Zone Substation – Royal North Shore Hospital

Preferred Project Report

March 2009

Prepared for NSW Health in conjunction with Energy Australia

Sheet Subject  
**26m TRUCK TURNING PATH PLAN - OPTION 1 FORWARD ENTRY**

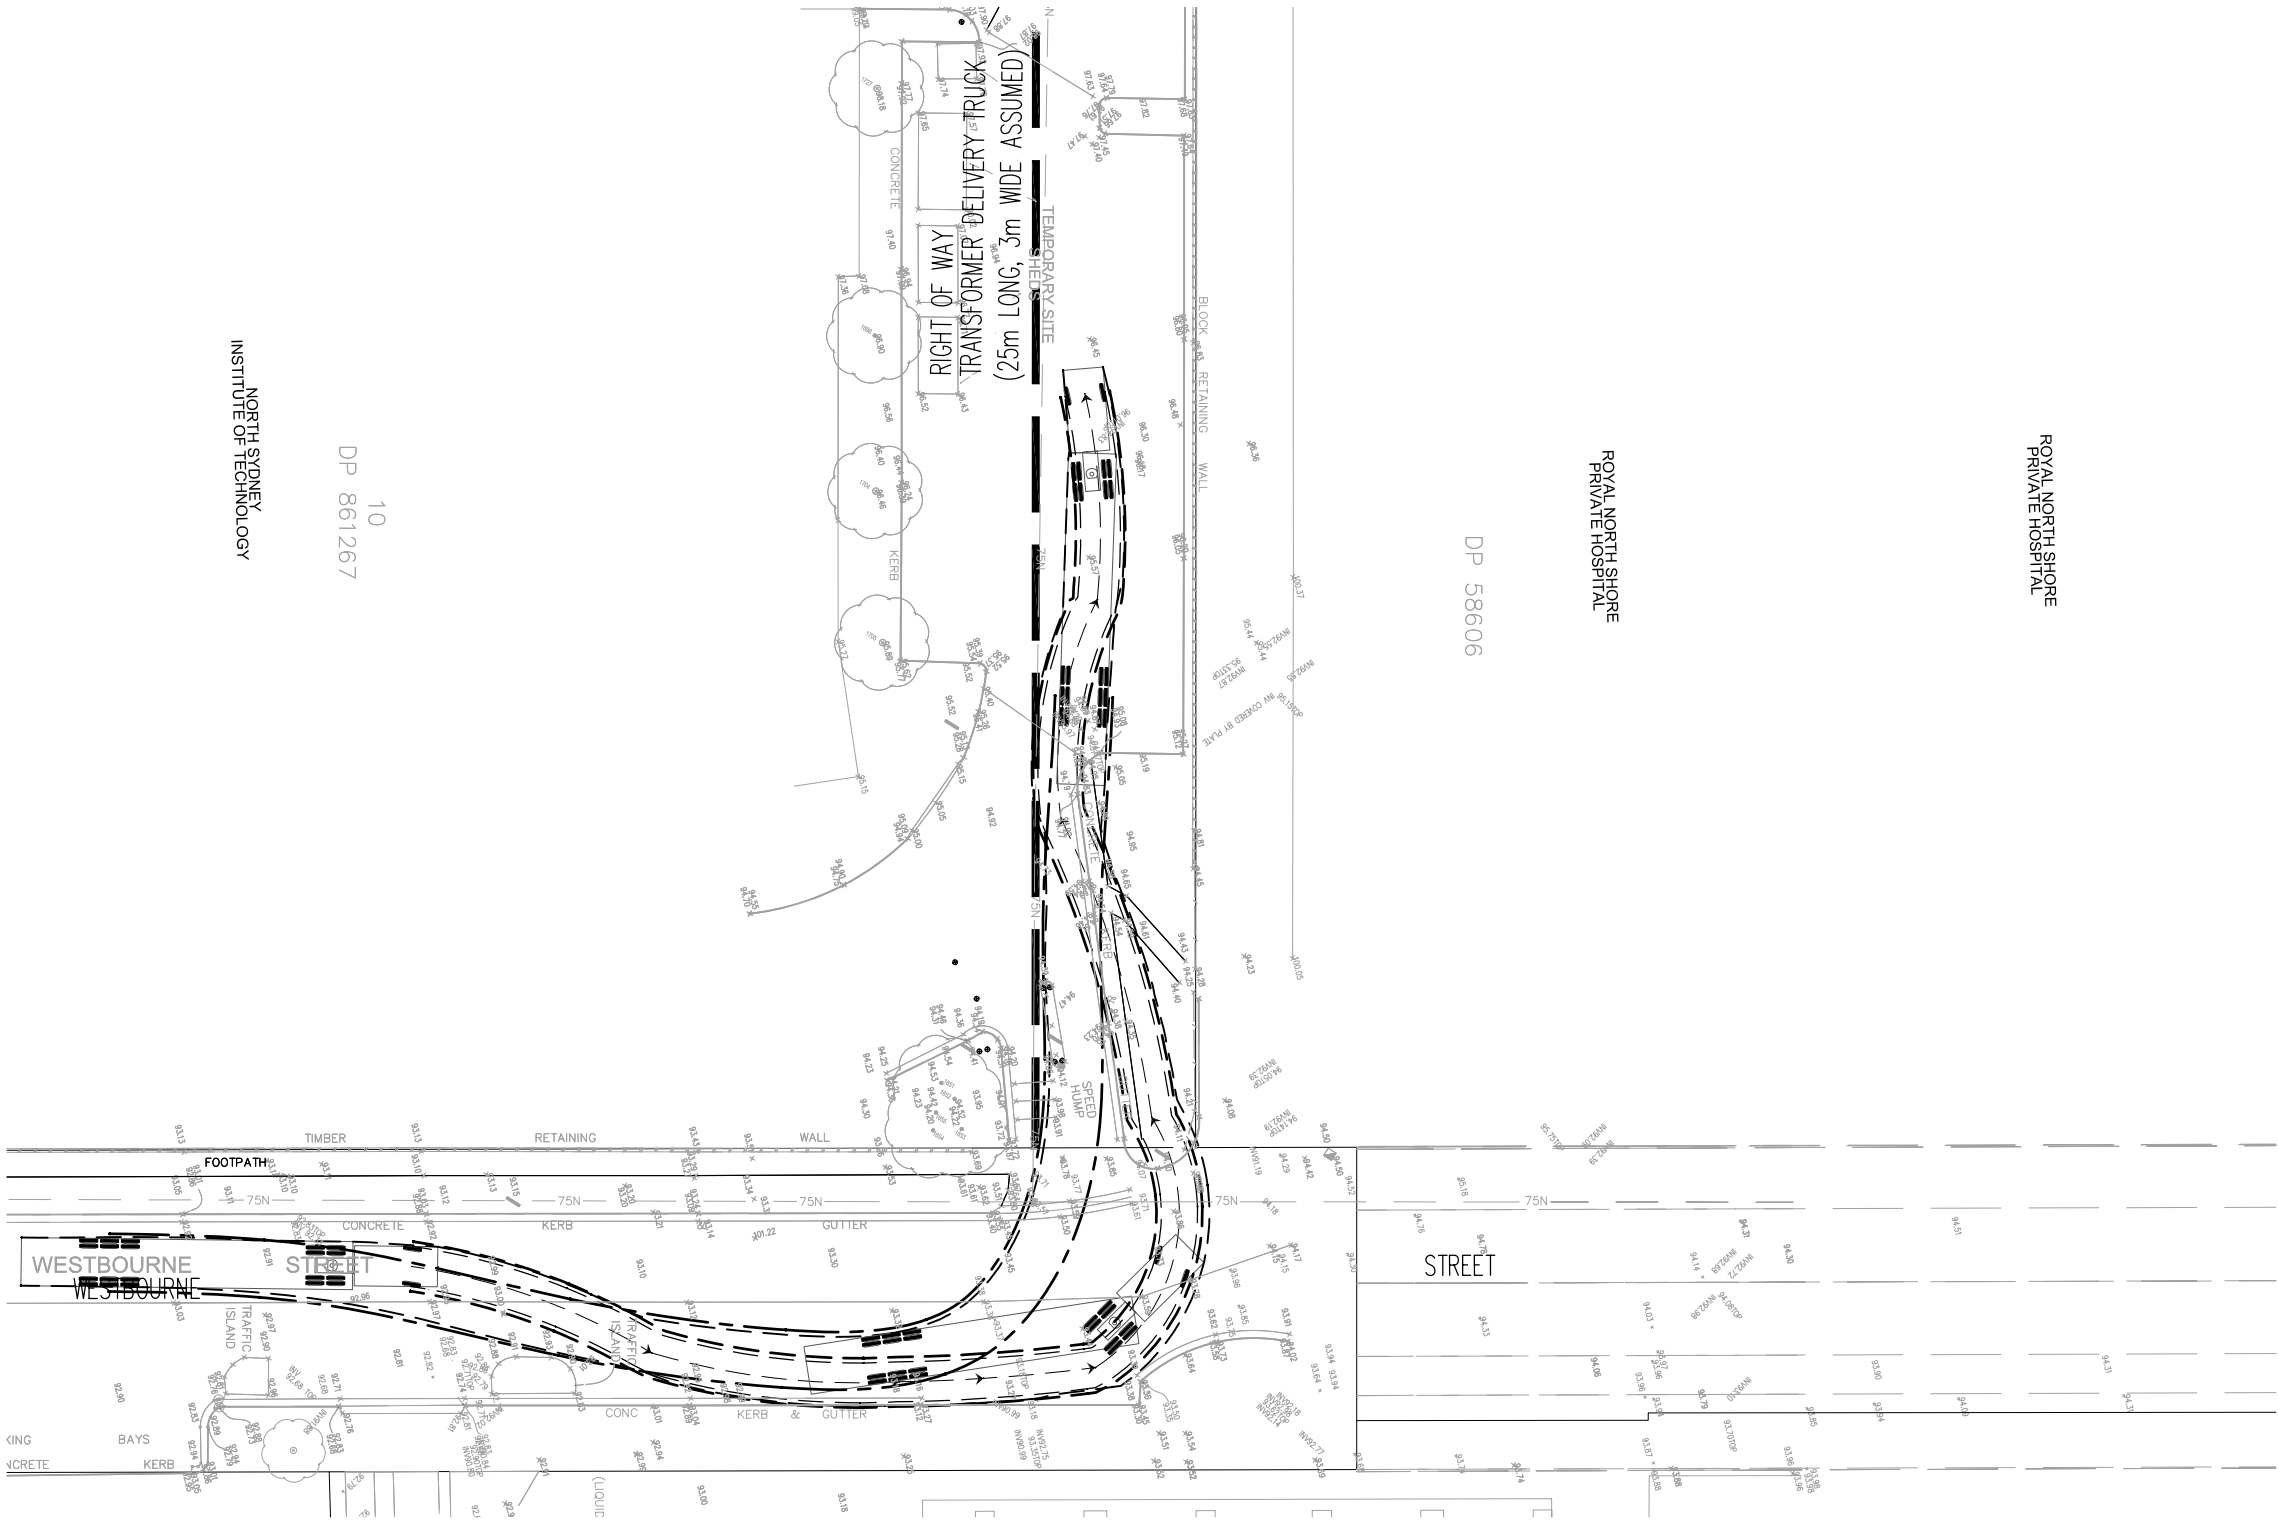
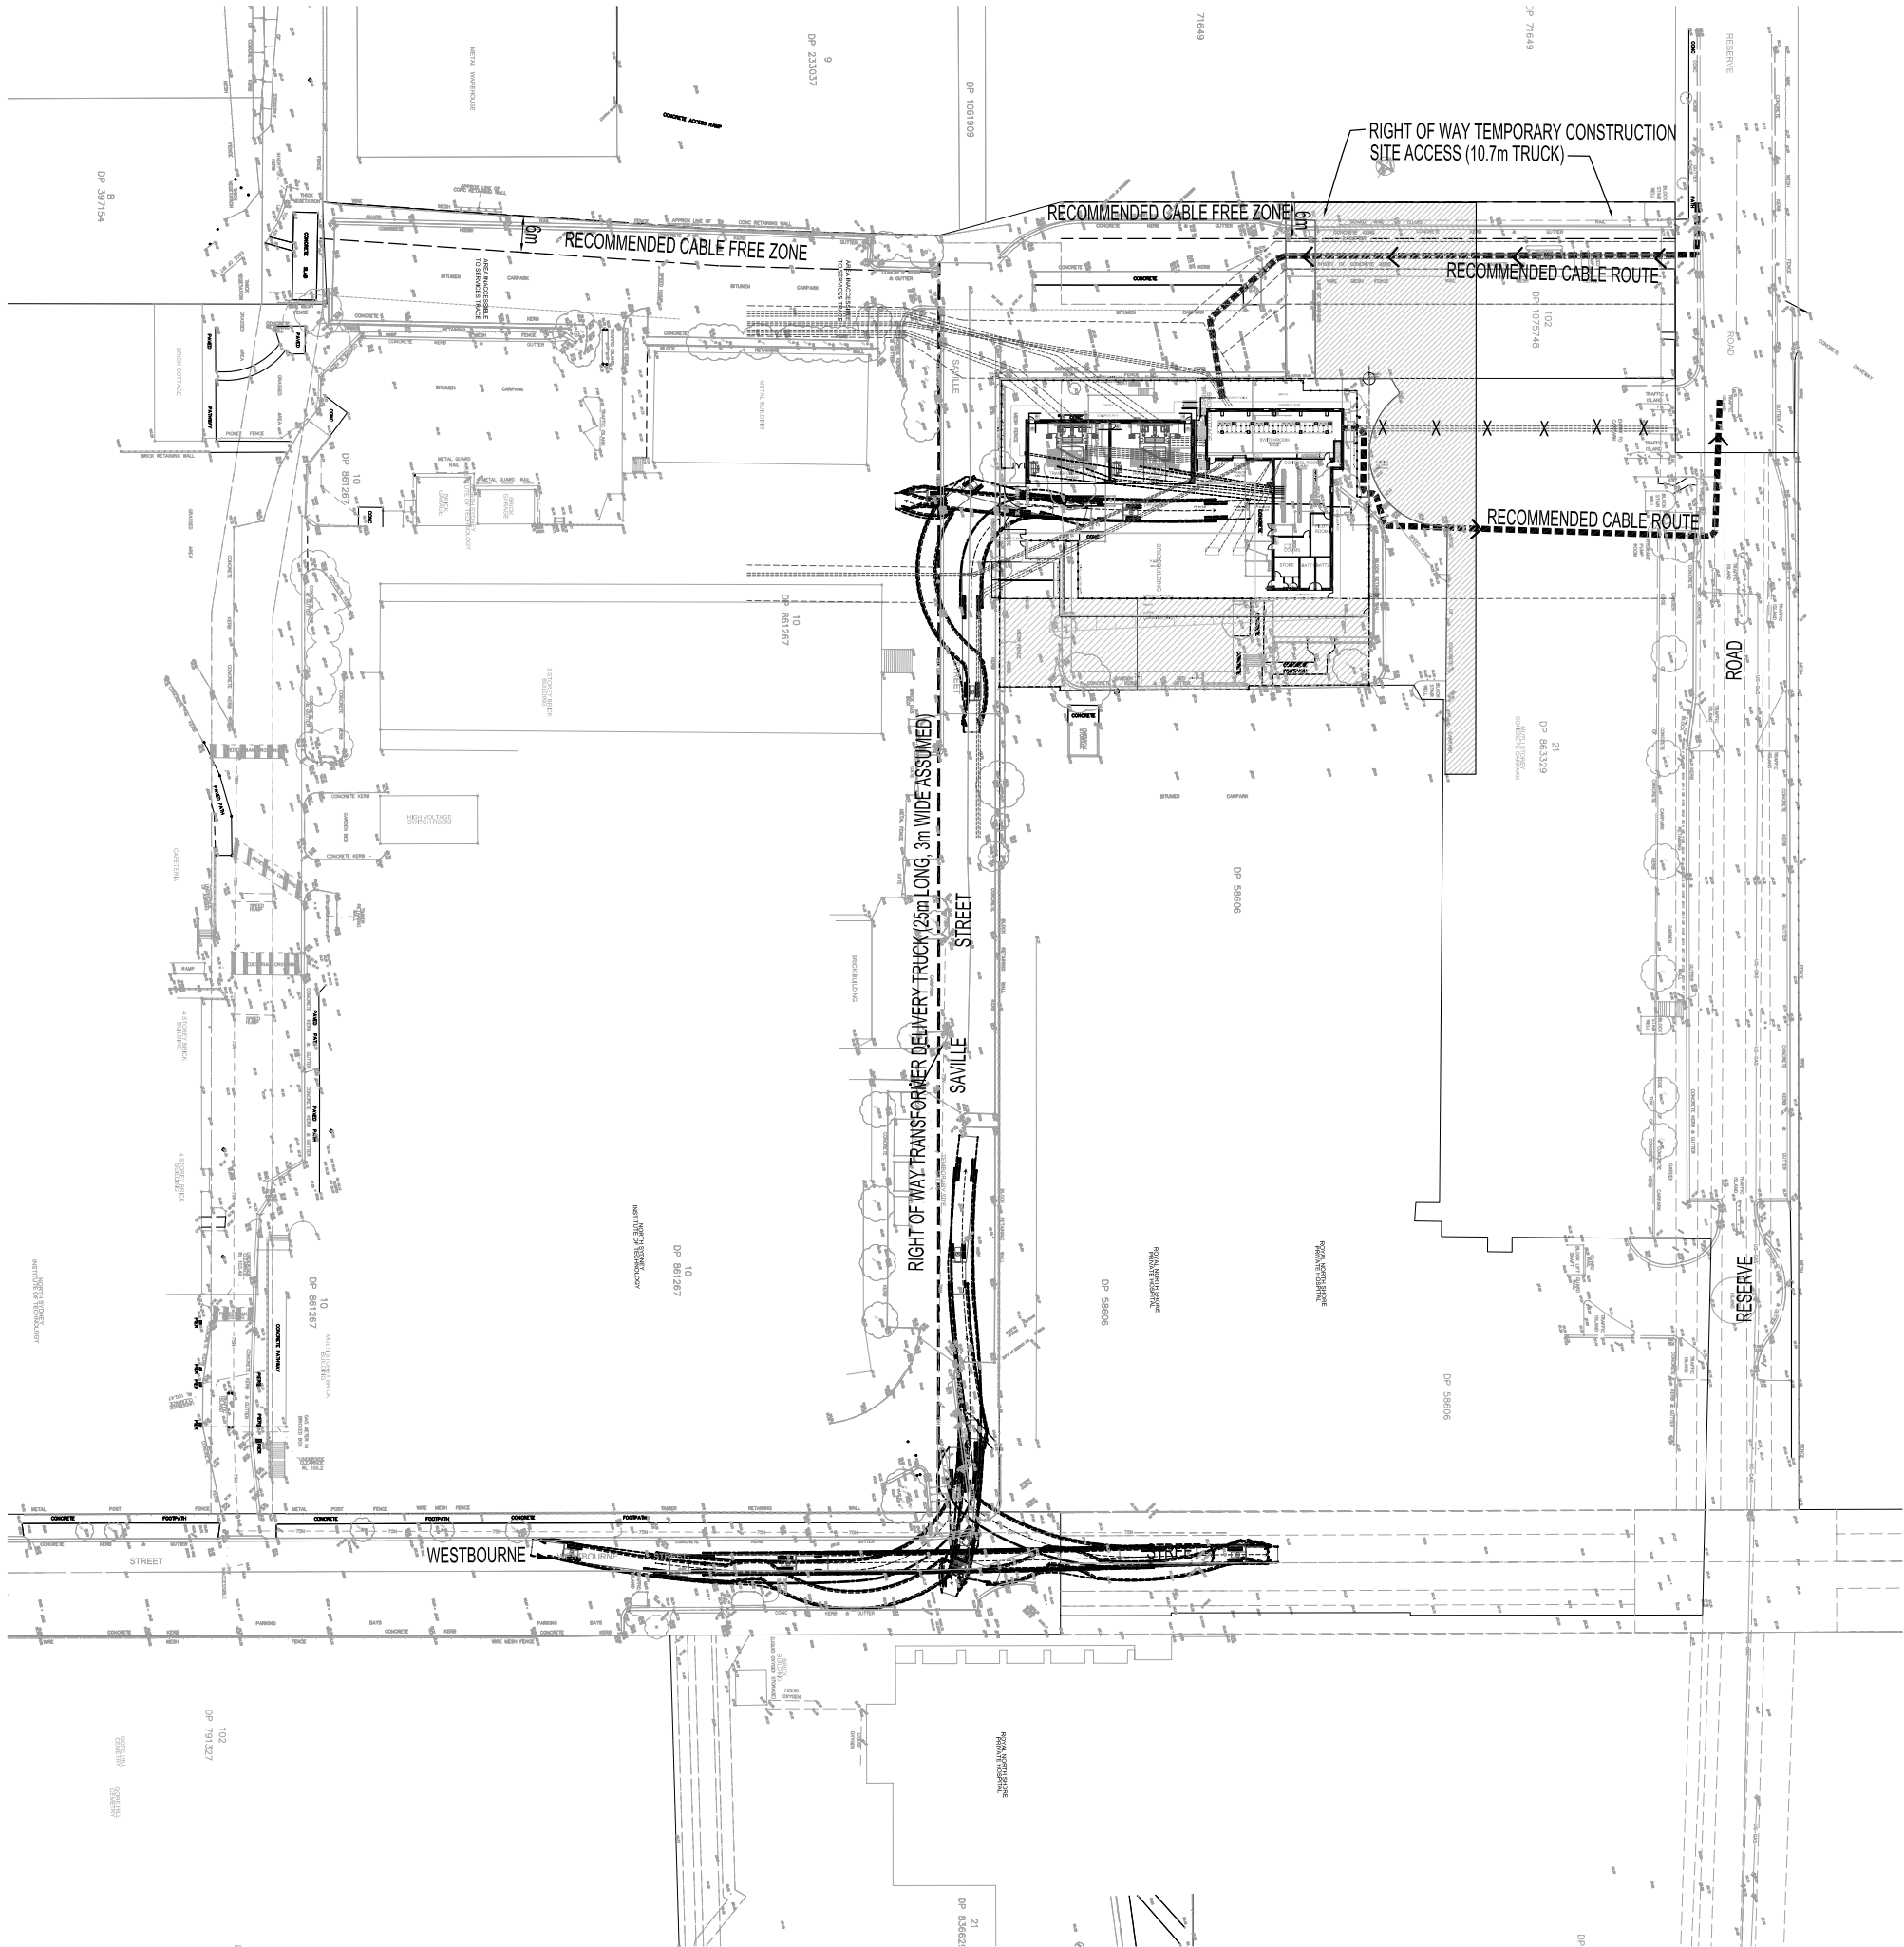
- e) *A heavy duty road is proposed to be constructed on the Northern Sydney TAFE site (Saville Street) along the common boundary with NSPH, to service the proposed EA Zone Sub Station. Whilst no specific details have been provided as to capacity or construction, the potential for damage to the existing NSPH light weight retaining wall along the boundary could be significant and result in loss of service access and consequential damages. Given that the NSPH retaining wall is an existing structure and has been so for many years, we would expect that EA should be required to accept full responsibility for this risk and underwrite any loss or damages incurred by NSPH as a result of failing to do so.*

However it should be noted that as a result of the NSPH extension now containing only a single level carpark, and EnergyAustralia's requirement that no heavy duty road is proposed as part of this development, impacts are extremely unlikely.

**EASEMENTS TO BE ACQUIRED, TEMPORARY LICENCES TO BE ACQUIRED**

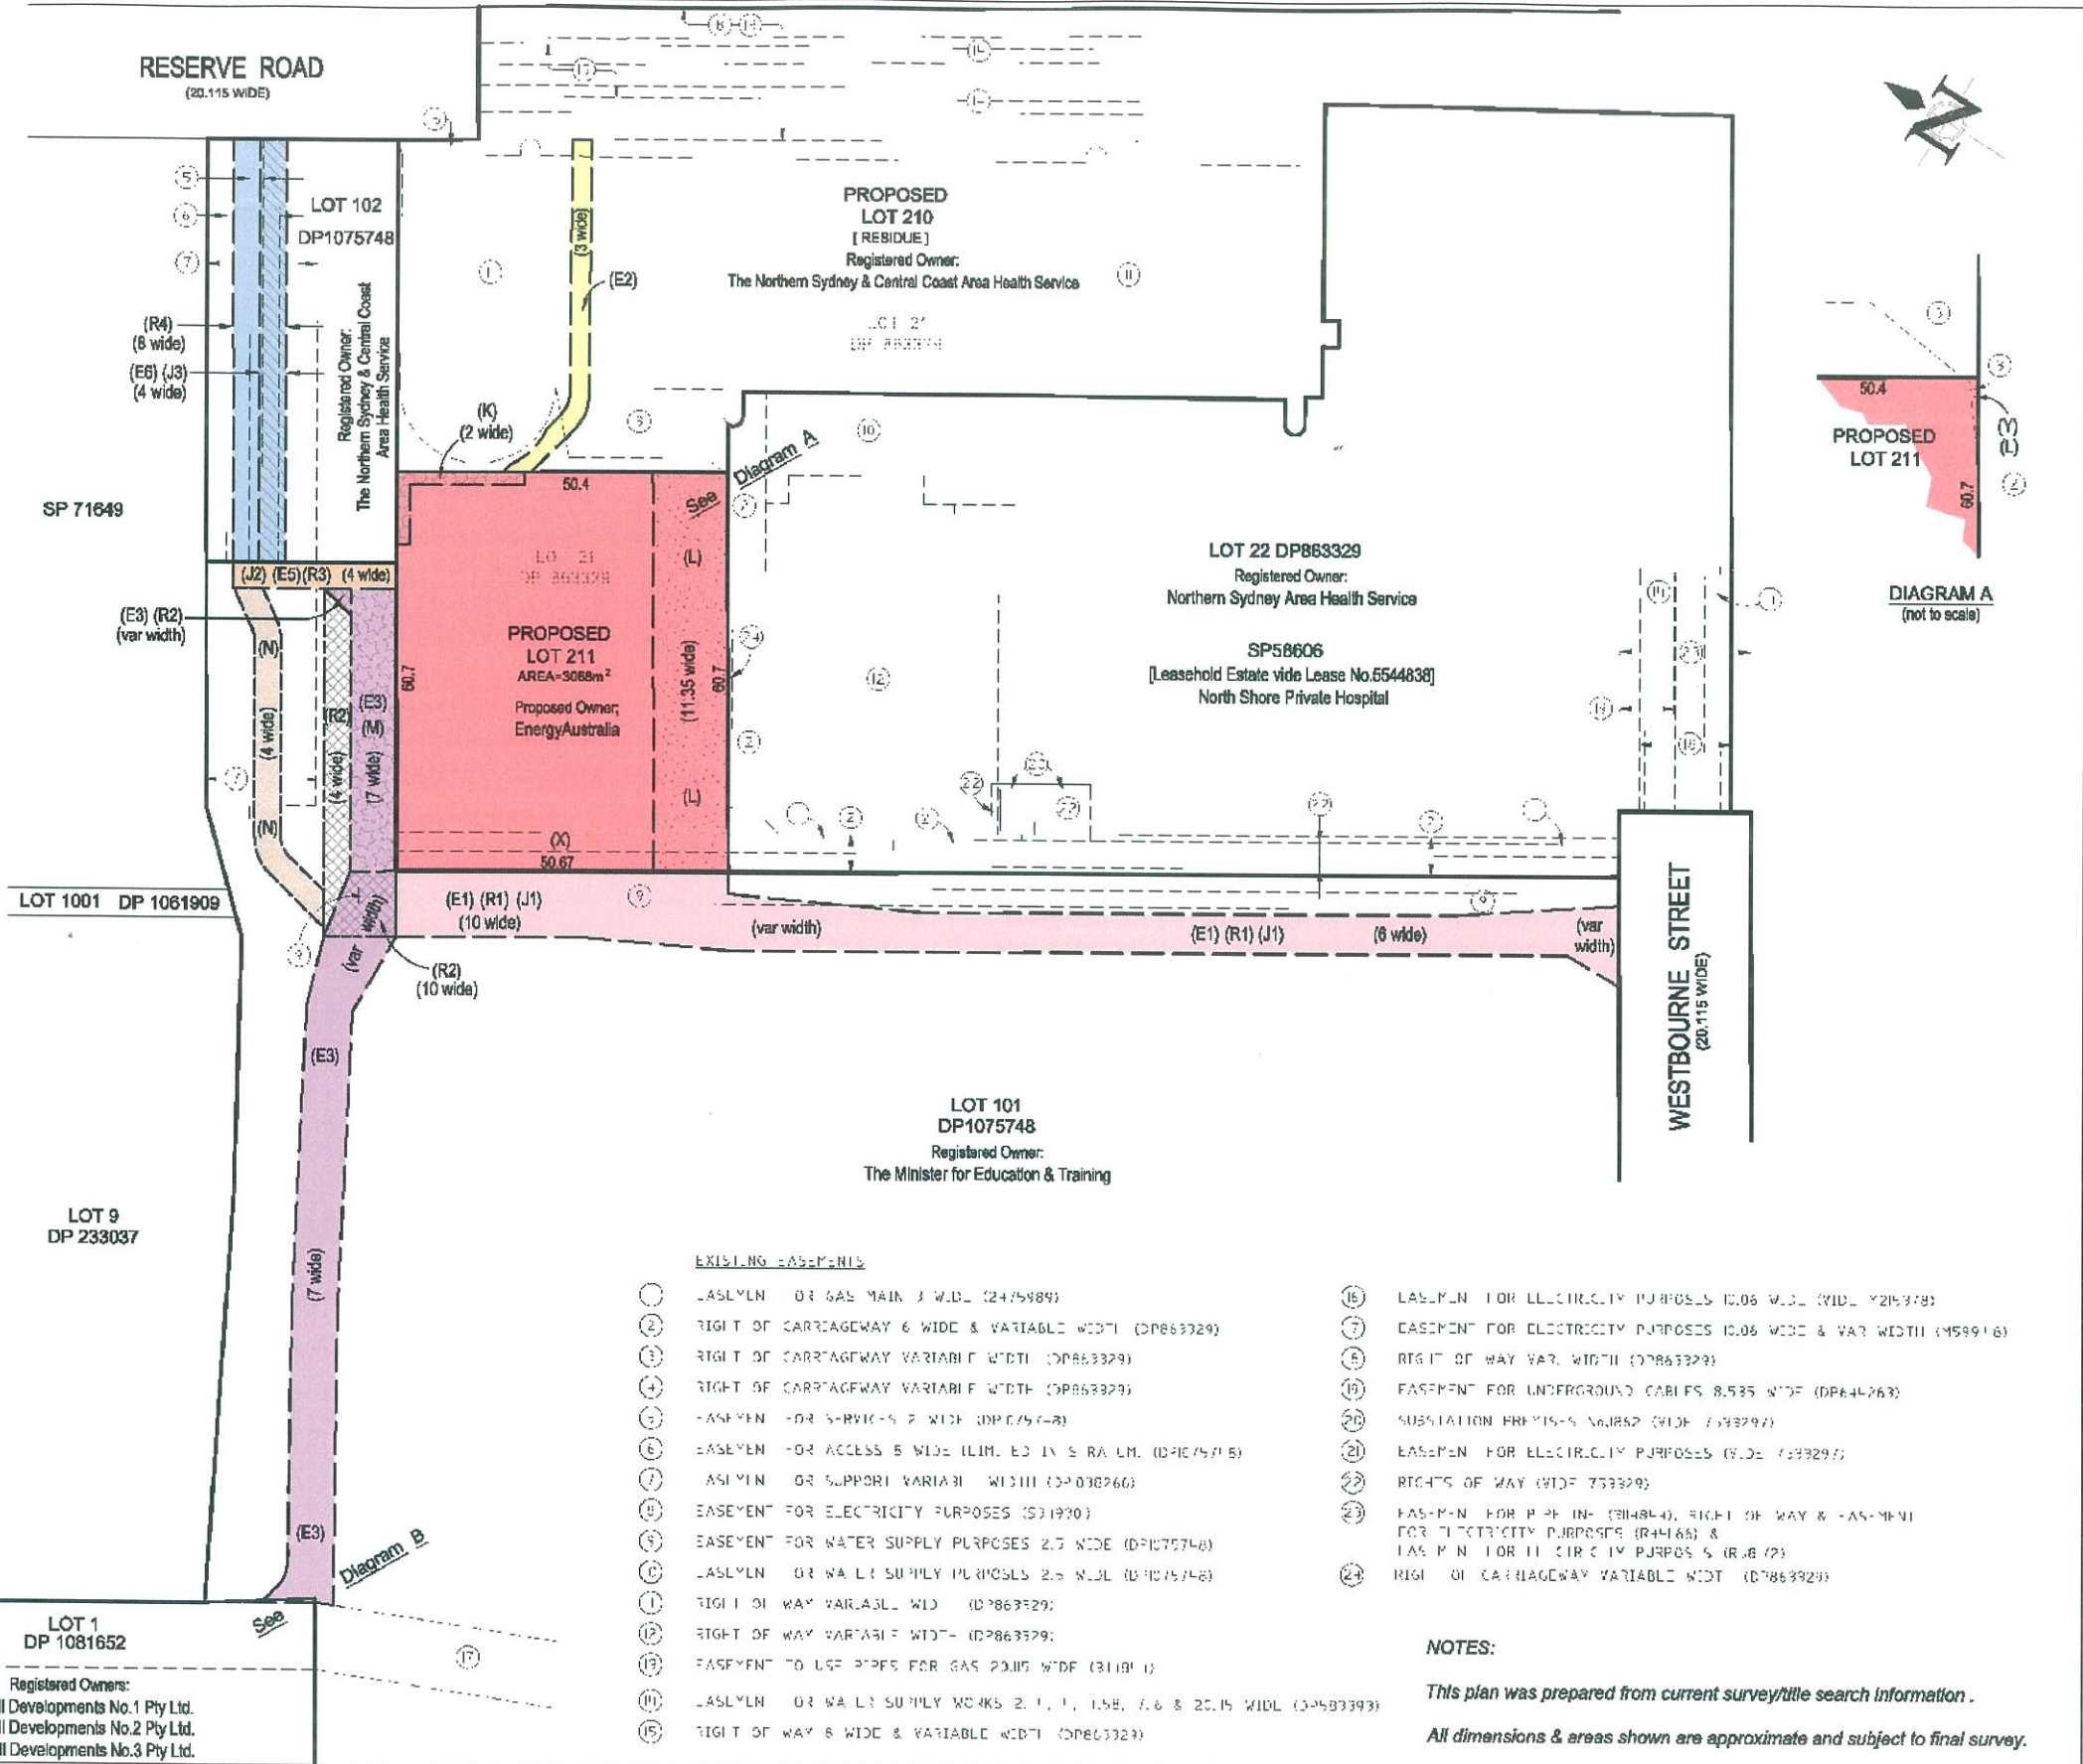
- b) Several of the EA Zone Sub Station drawings and perspectives may be misleading as they do not show the true relationship between both the EA and NSPH developments **on completion**. In particular, the NSPH development will be constructed to the common boundary leaving some 15m buffer zone to the Sub Station compound – not 15m plus the current 50m NSPH ground level car park as drawn.

- b) The 14.3m buffer zone to the common boundary is consistent with the executed Deed of Agreement clause 9.2(a)(i). The obligation for Energy Australia and NSPH to treat a common property boundary as a fire source feature is the same regardless of NSPH DA documents. We understand NSPH's revised design, submitted in their S96 submission, has only recently come off exhibition and has yet to receive development consent.
